Application number: 2019/93284	
What is the application for?:	Alterations to convert former church to 6 dwellings
Address of the site or building:	Clayton West United Reformed Church, Church Lane, Clayton West, Huddersfield, HD8 9LY
Postcode:	BD20 5PF

Type of comment: An objection

DRAWING TITLE: PROPOSED ELEVATIONS & SECTIONS

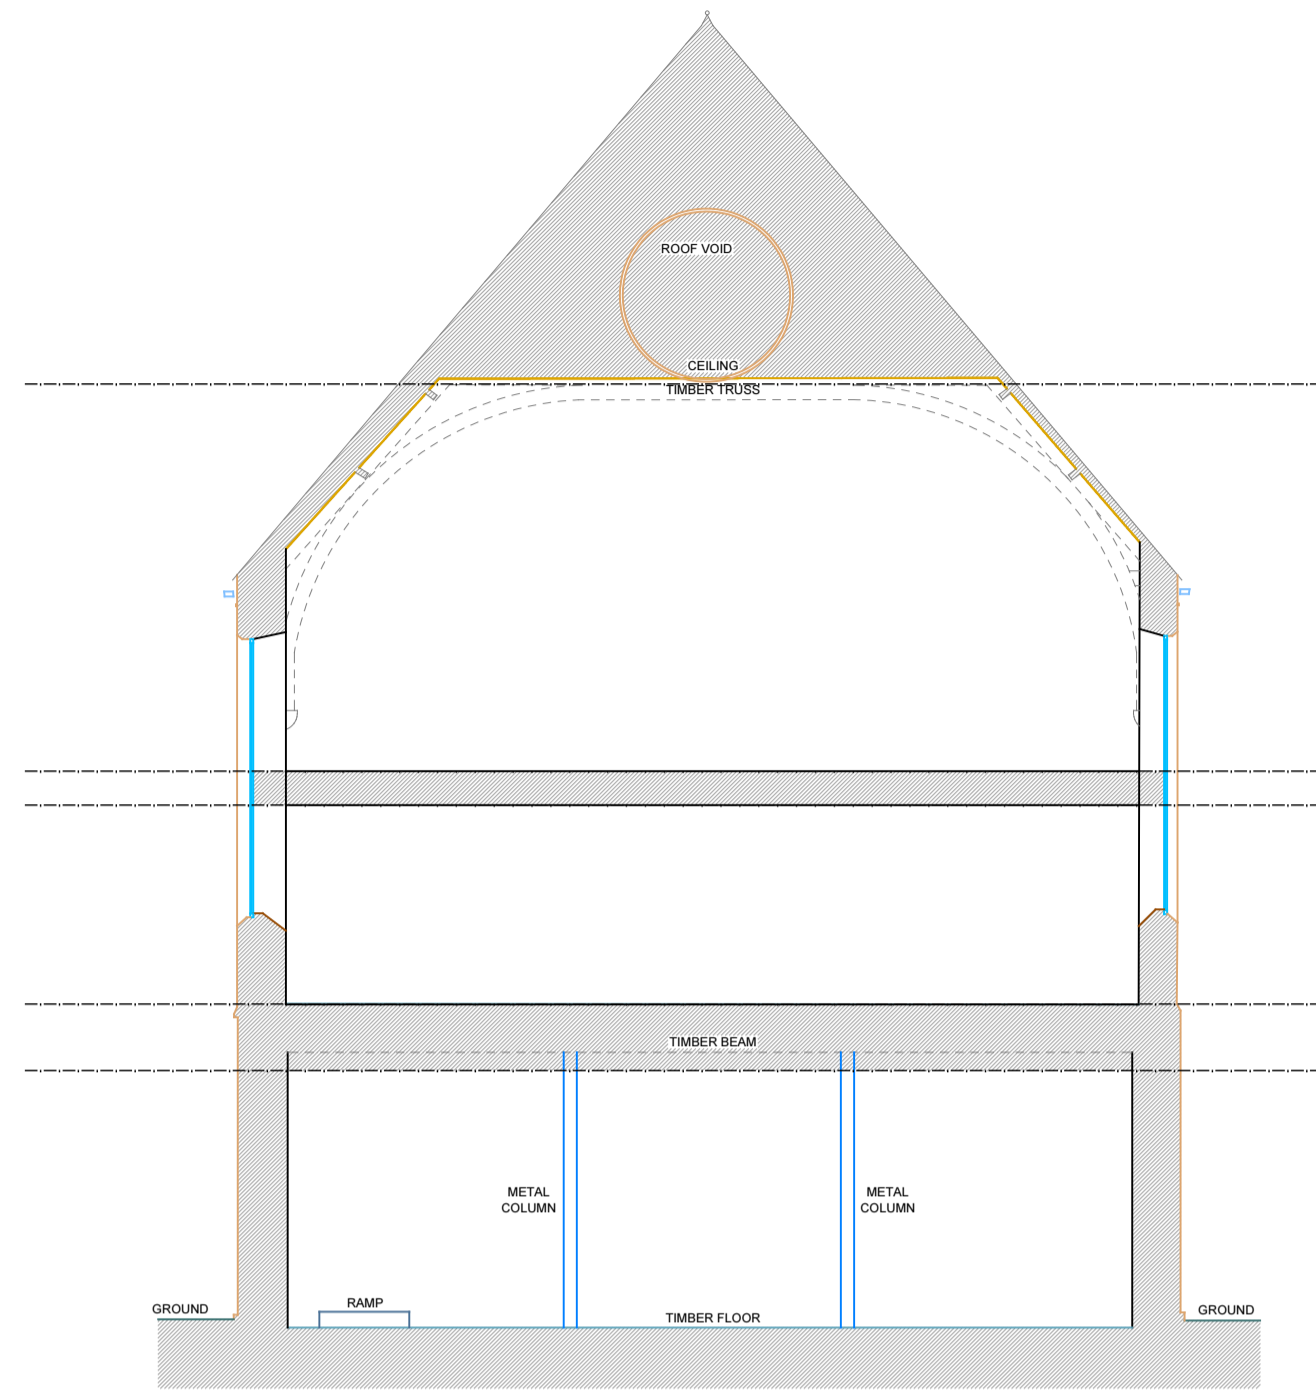
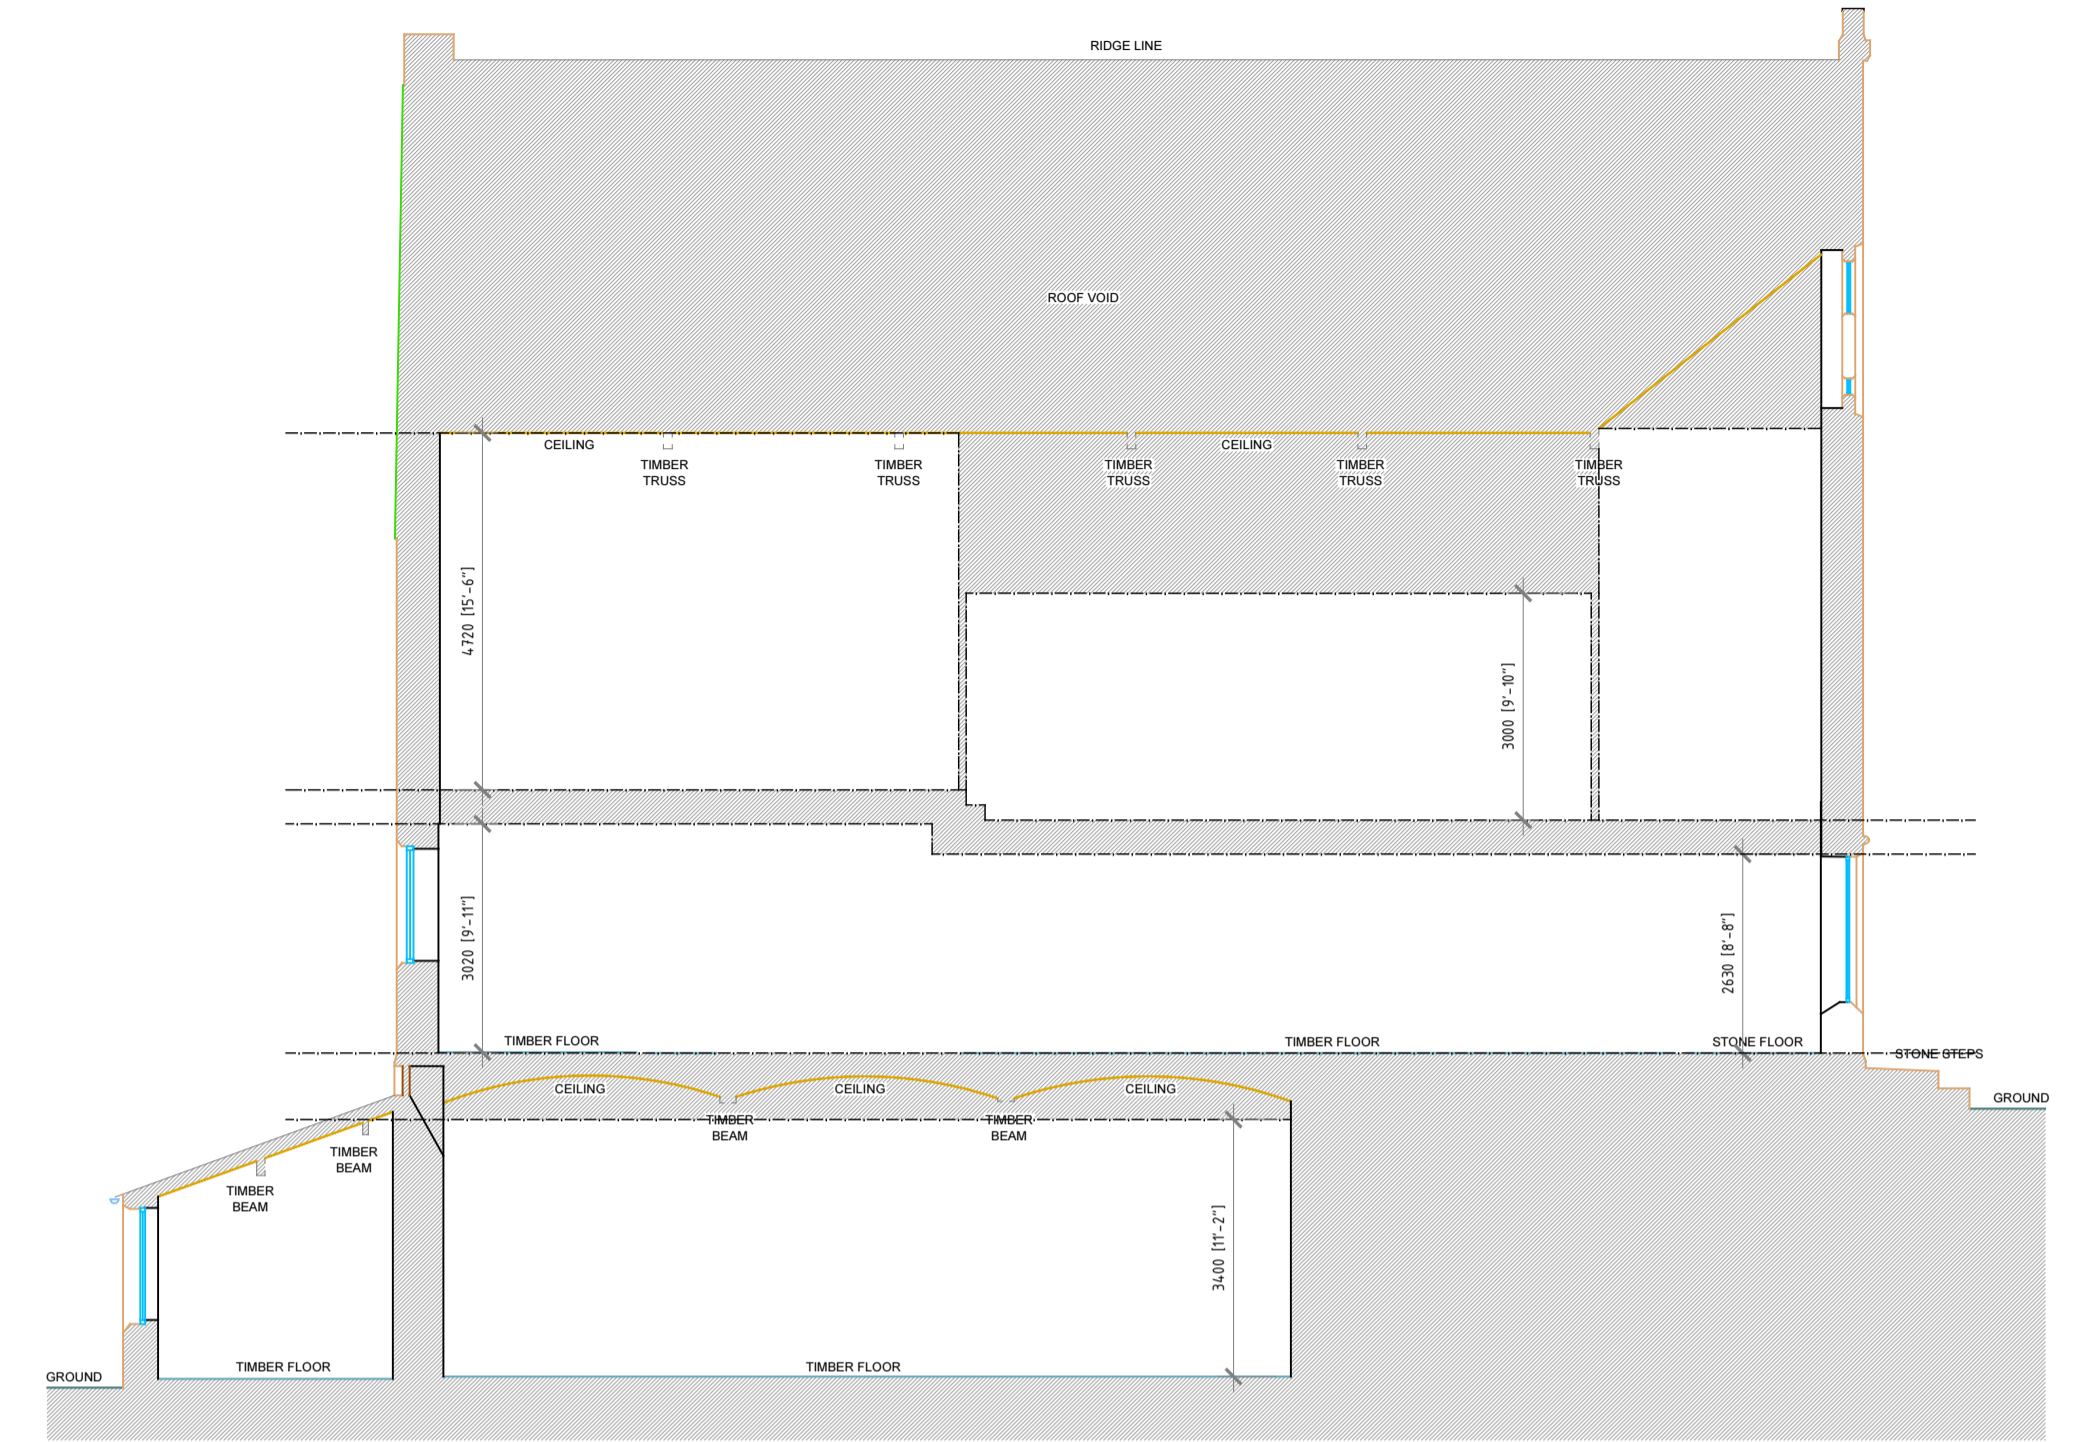
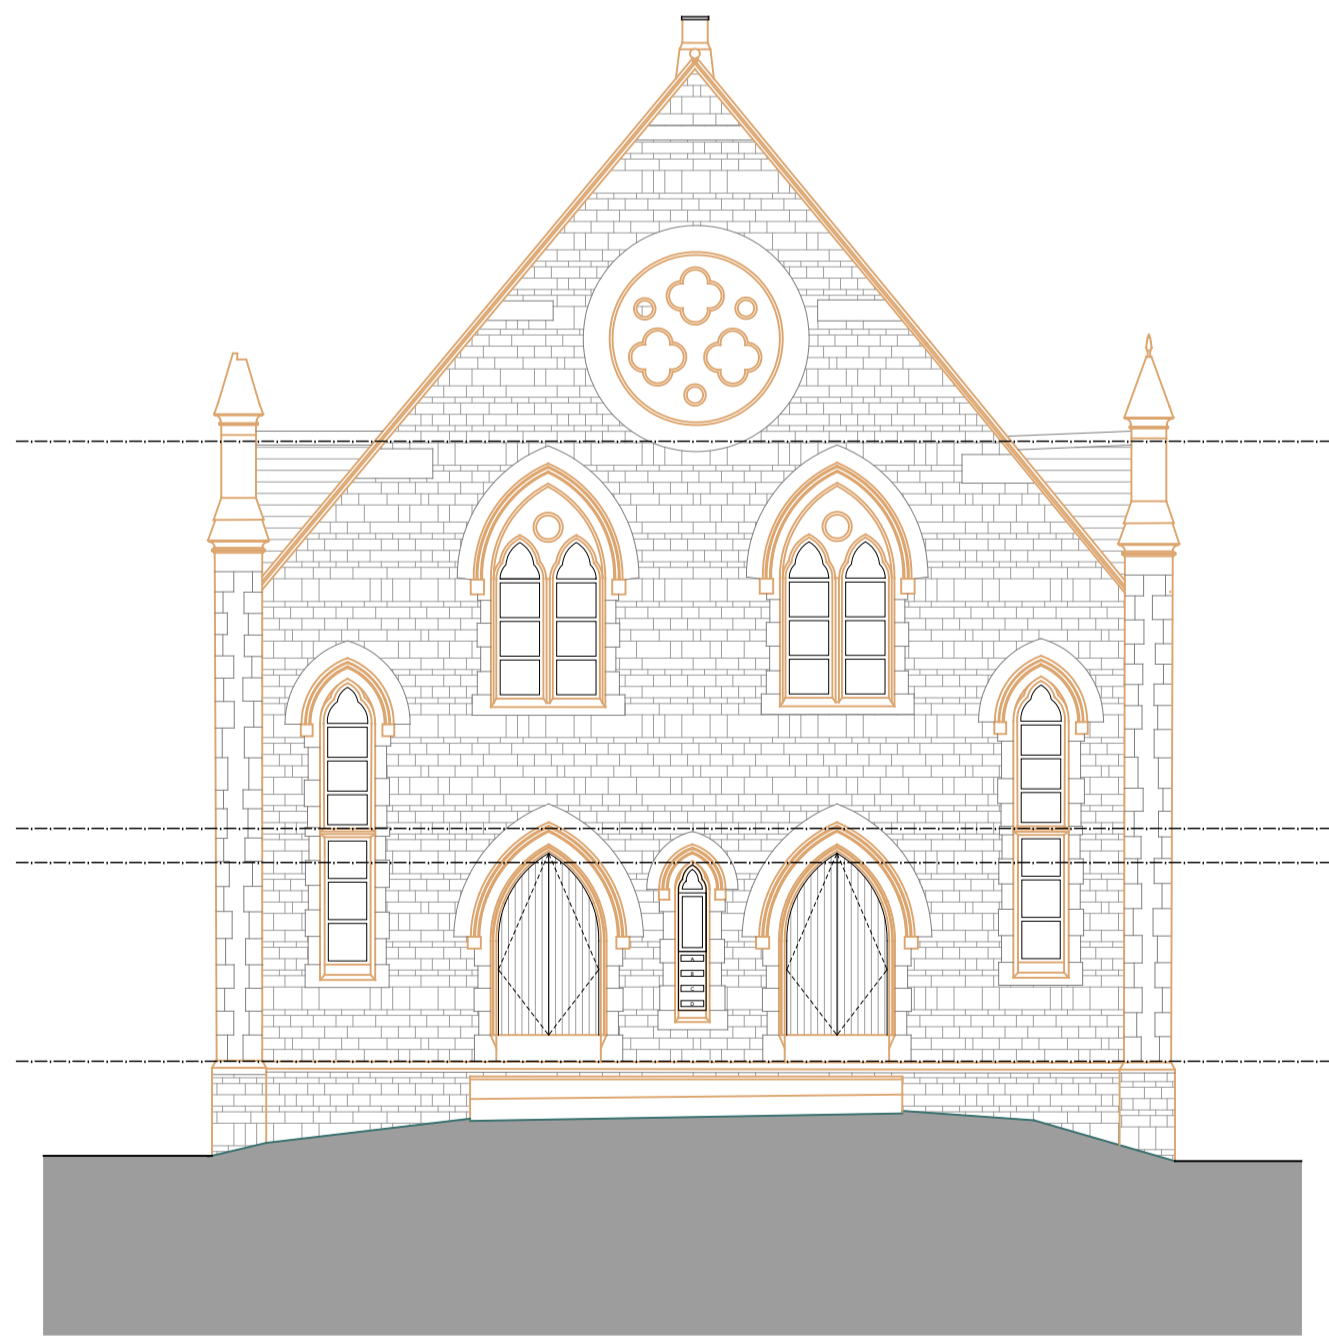
Firstly, we believe that our privacy would be significantly compromised as a result of the proposed new windows to the rear of the church.

the rear of the house. We specifically chose to purchase our house, because of the church behind us, to avoid being overlooked. The windows will also look
